DEVELOPMENT REVIEW BOARD  
SUPPLEMENTAL SUBMITTAL

PROJECT NO. 2018-001579

SUBMITTAL DESCRIPTION: Departmental comments indicated a number of items to be addressed in a deferred hearing date, indicated above for multi-family apartments project at 7500 Indian School Rd in the Winrock Town Center. Responses to the comments and revised sheets are provided.

This letter outlines the modifications that have been made to the Apartments at Pennsylvania St and Indian School Rd application for a major site plan amendment to the approved Winrock Town Center Site Development Plan (PR-2018-001579) to address the agency comments that were received.

SHEET NO. SDP1.1 OF

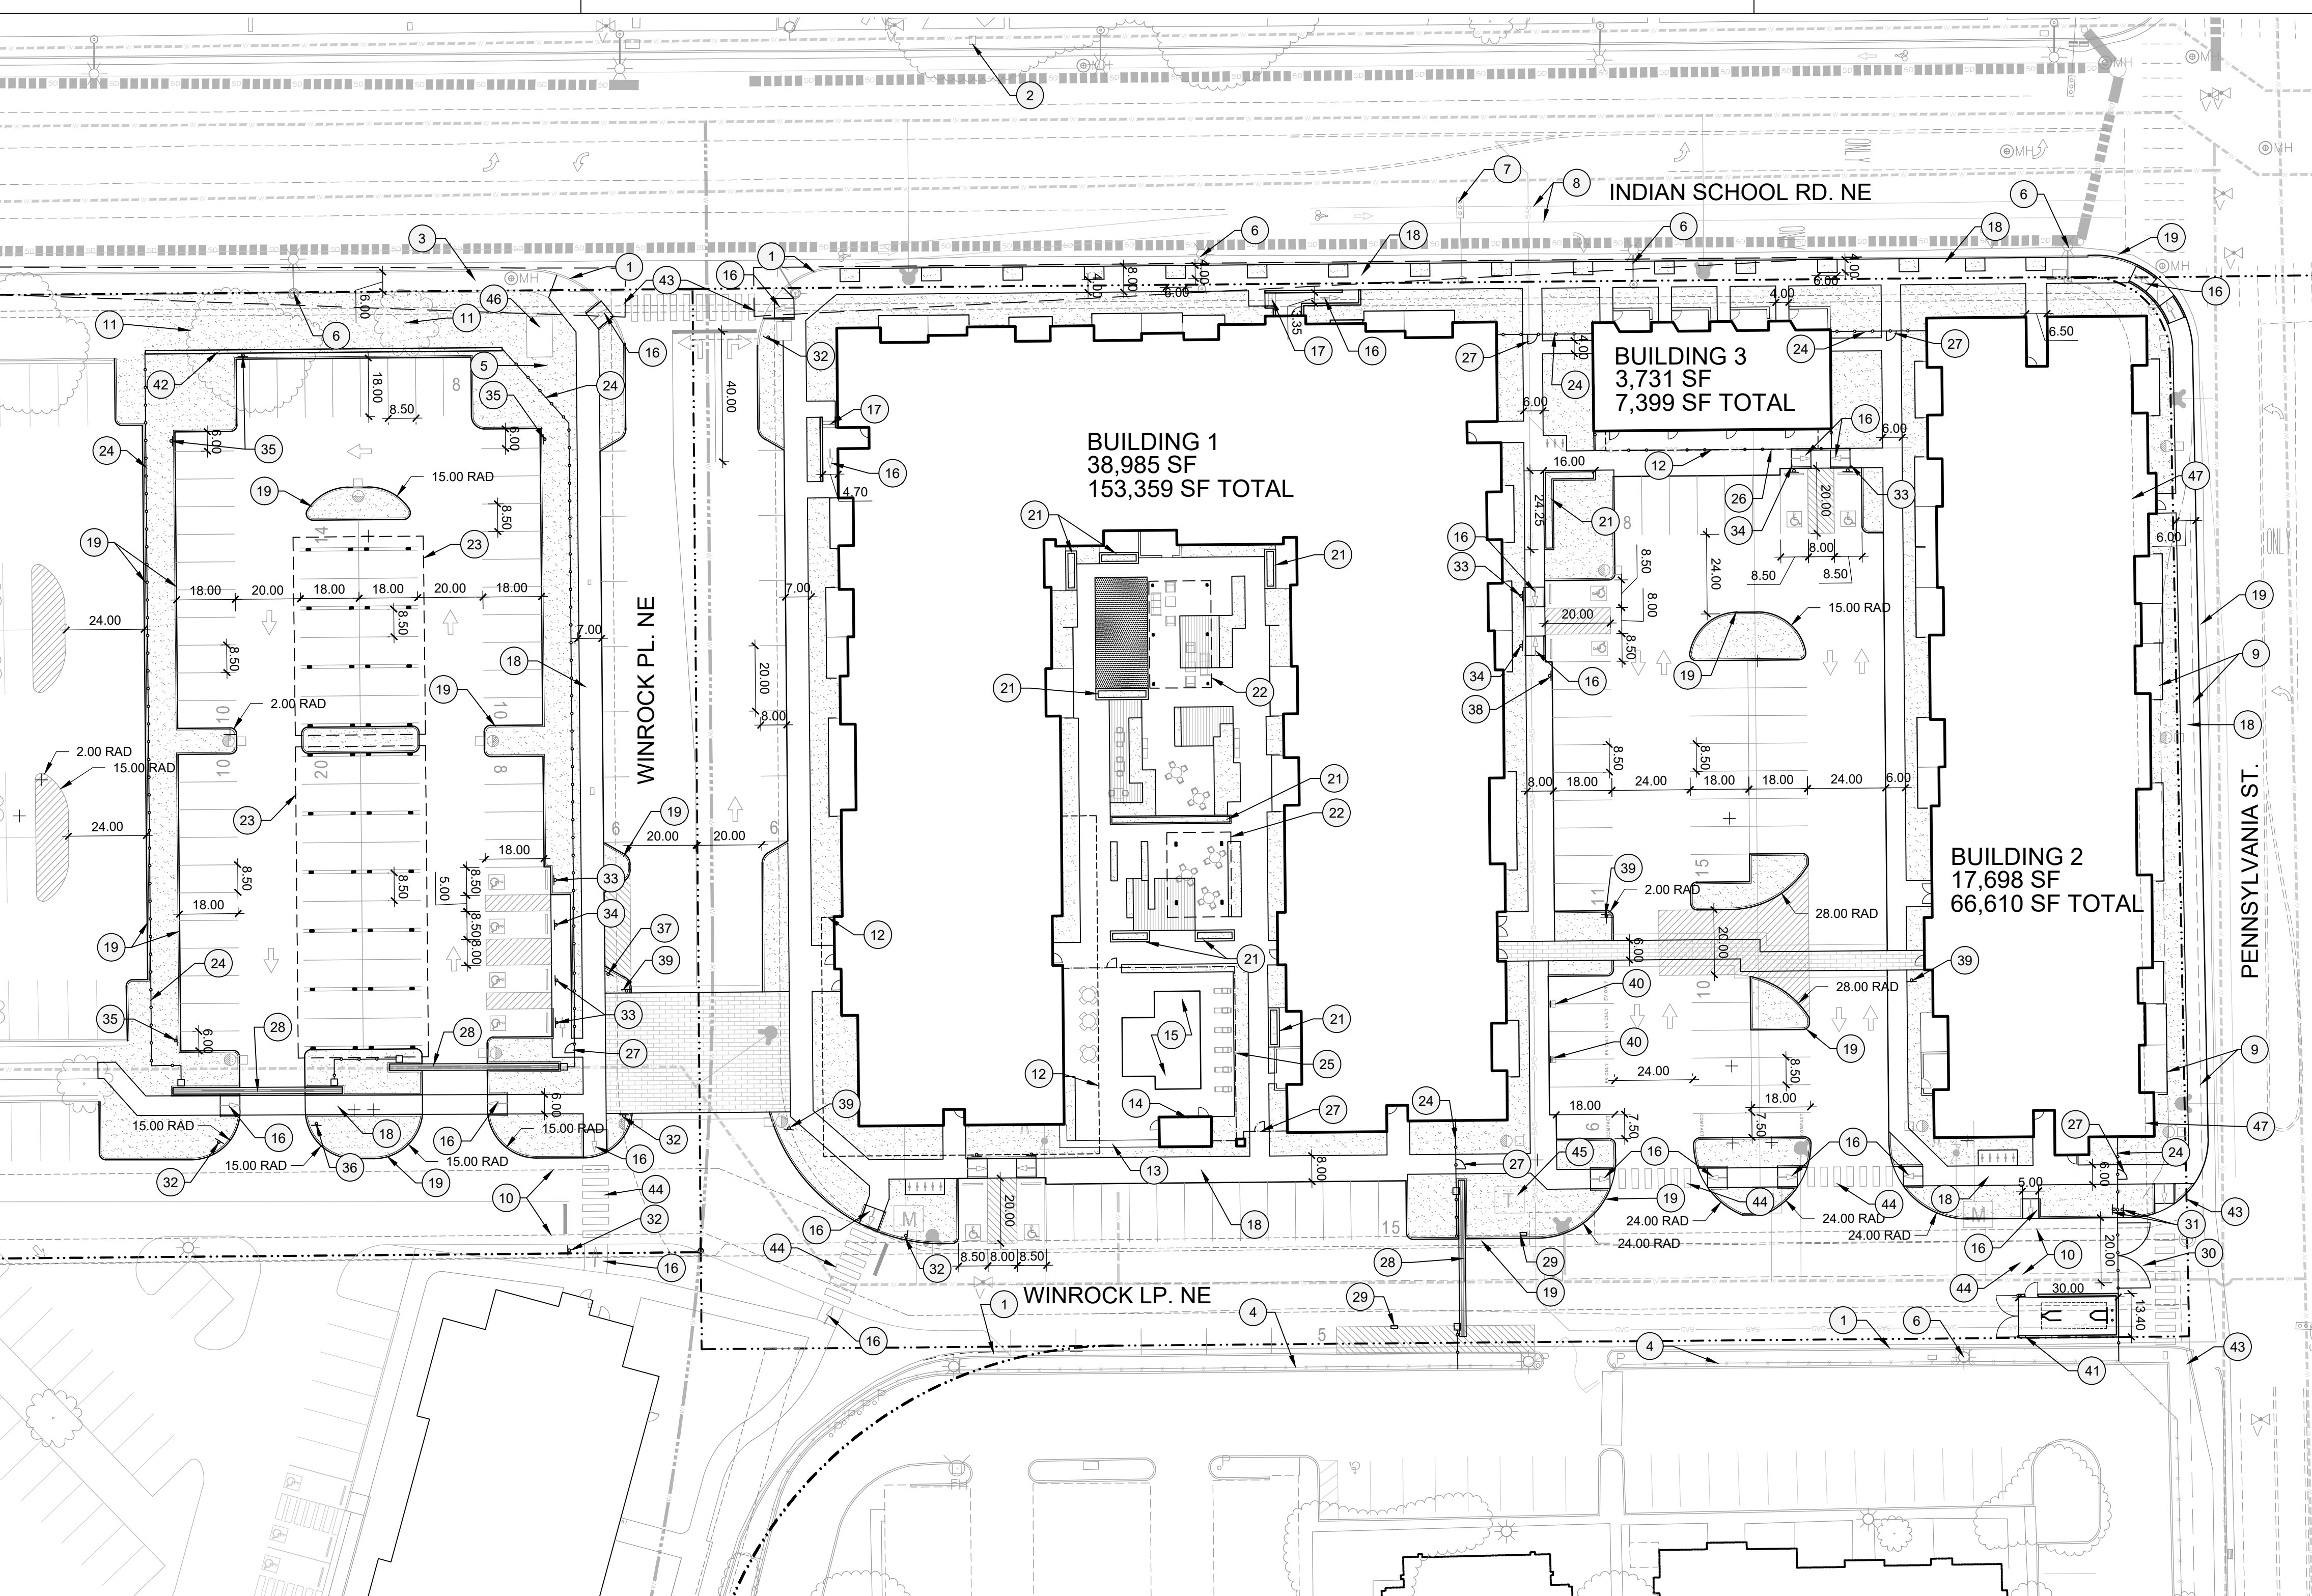
3. For road exiting onto Indian School Road, show a cross-section. Used a keyed note for striping and include a note for the centerlane lane as well. Show proper transitioning. Call out pavement arrows, and provide dimensioning for the lanes.

5. Include “Emergency Access Only” signage on each side of the drive off of Pennsylvania instead of just one side.

6. Include a keyed note for the bike rack location for clarity.

8. A curb ramp appears to be missing at the corner of Indian School and the emergency exit. Call out note for the curb ramp.

*Keyed notes for asphalt striping and directional arrows have been added. Road cross-section was added to sheet C400.*

*“Emergency Access Only” sign has been added to both sides of gate.*

*Keyed note has been added.*

*Concrete accessible ramp is keyed noted at the north corner of Pennsylvania and emergency access exit. There is an existing accessible ramp at the south corner of Pennsylvania and emergency access exit to remain.*

**SDP2.1**

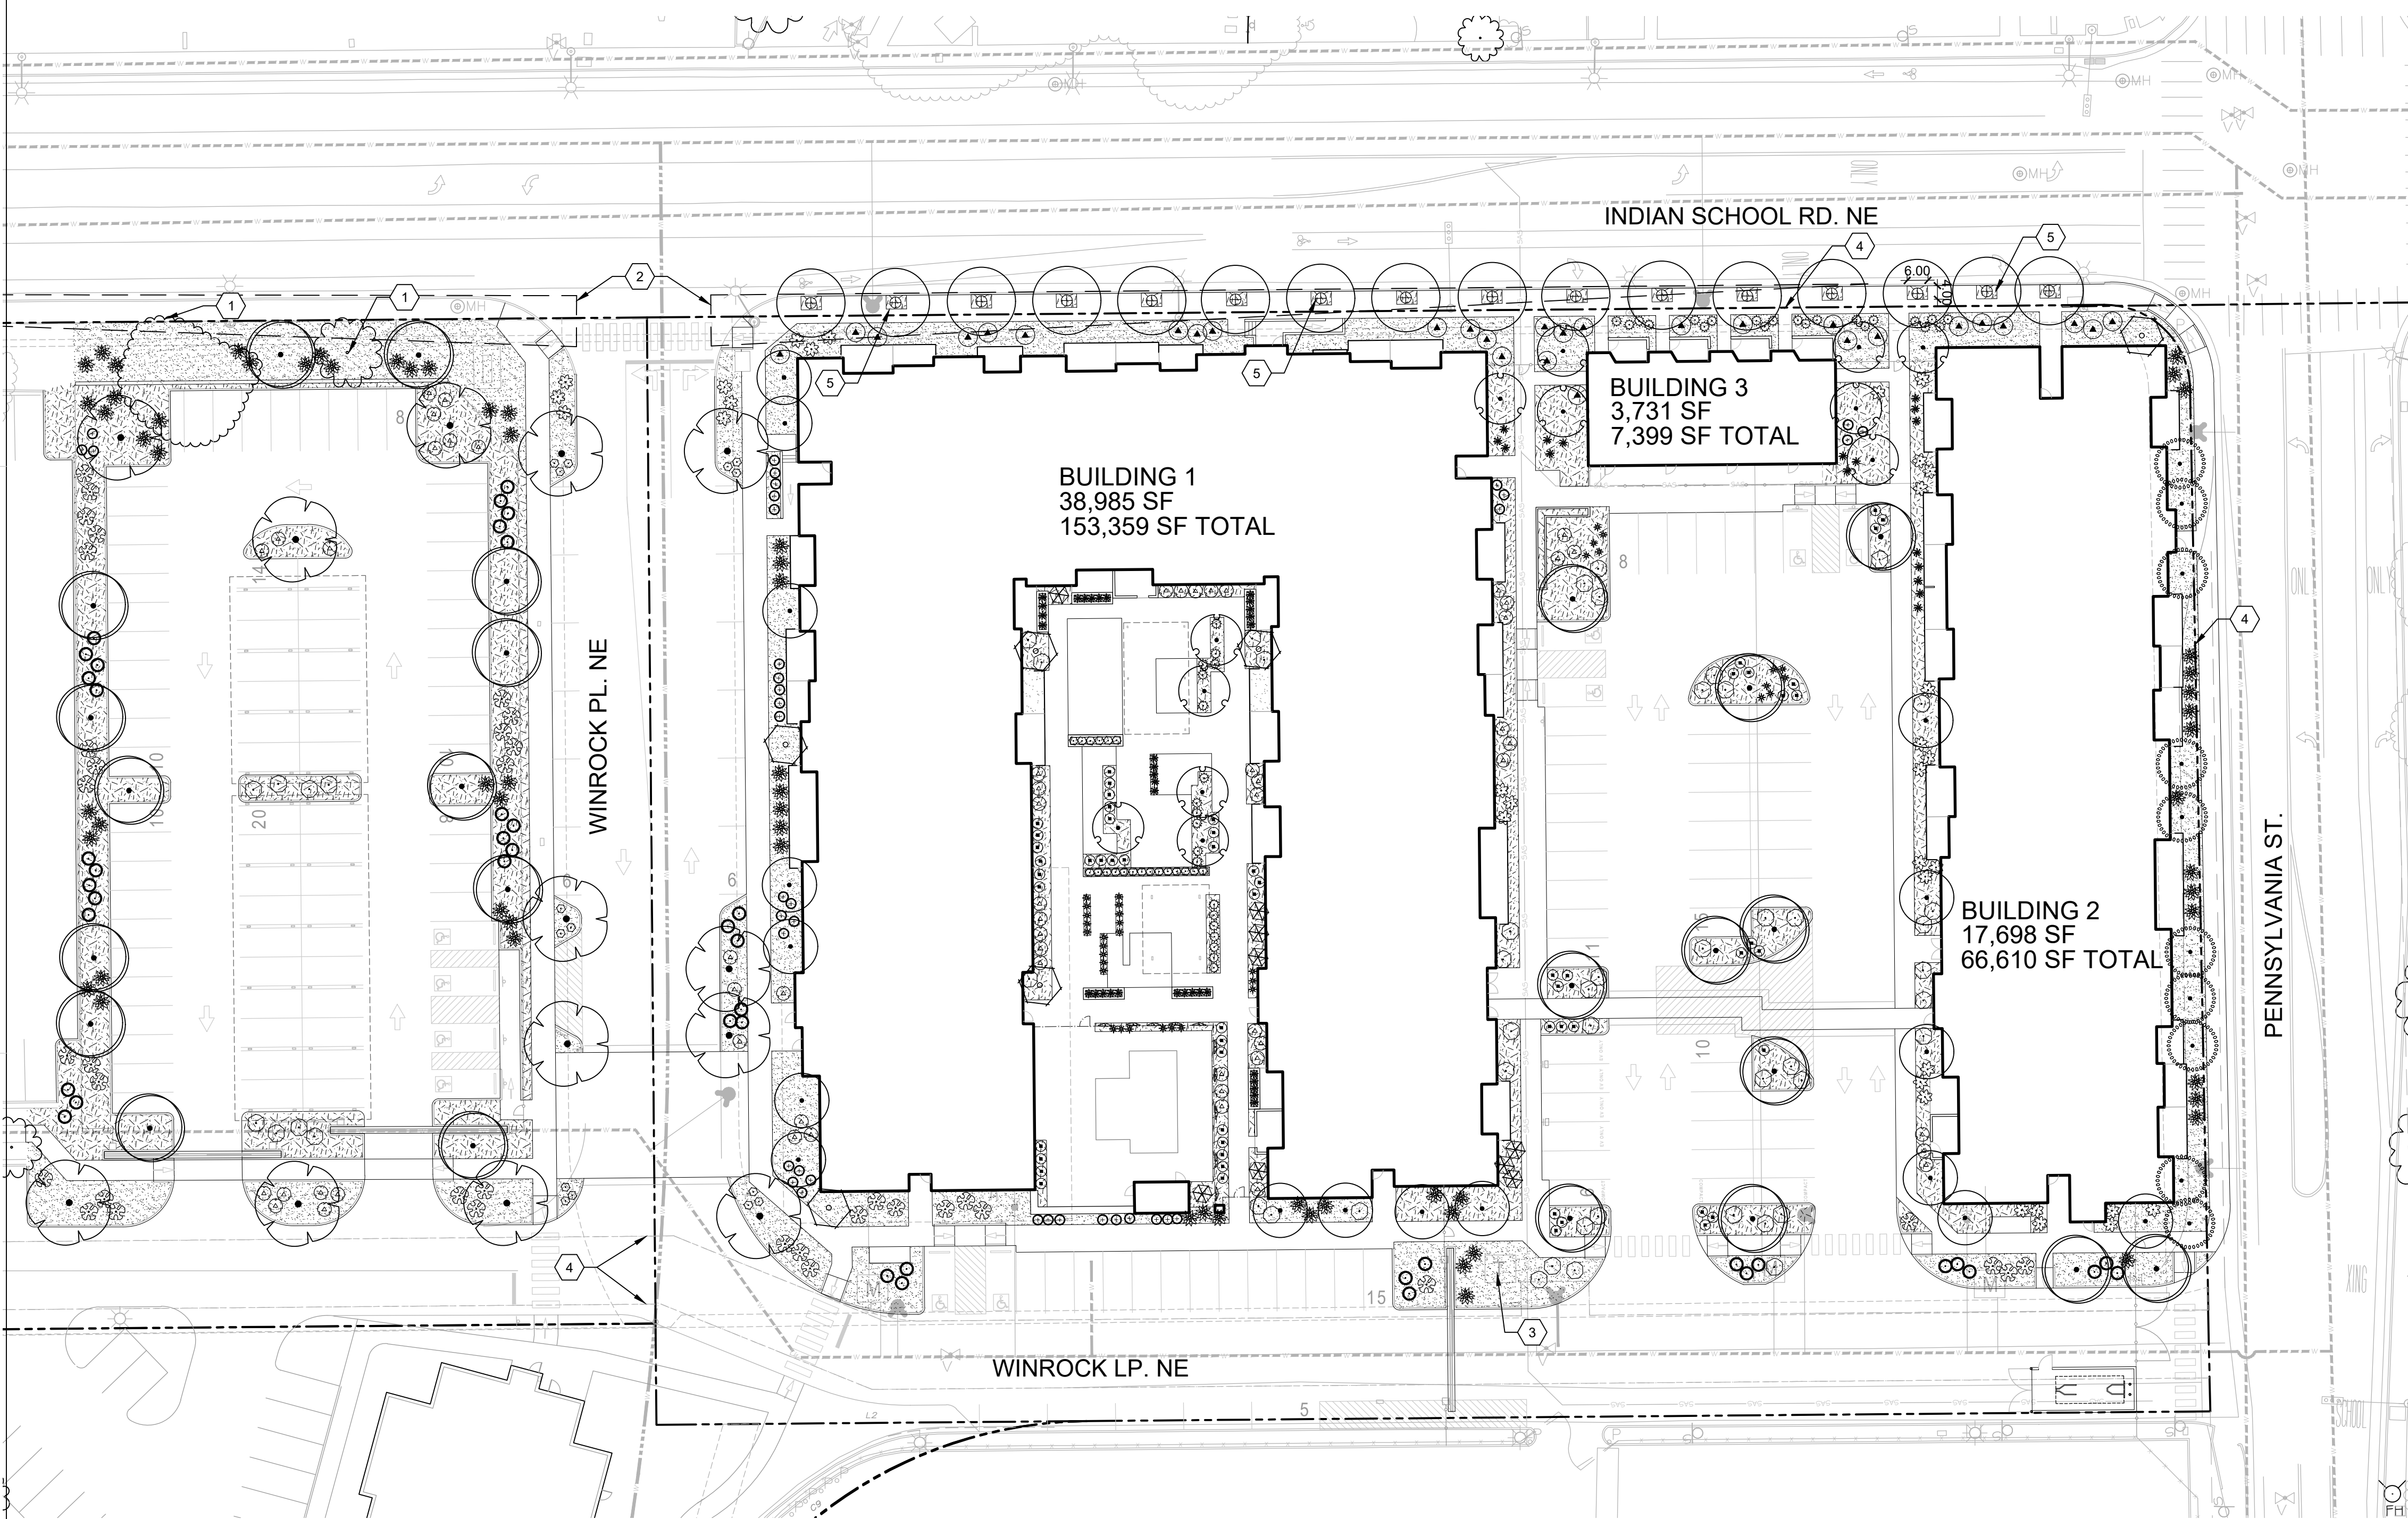
### 1. Confirm that all plant species are on the City's plant list.

*The applicant has revised the landscape plan to ensure that all plant species utilized are on the City's plant list.*
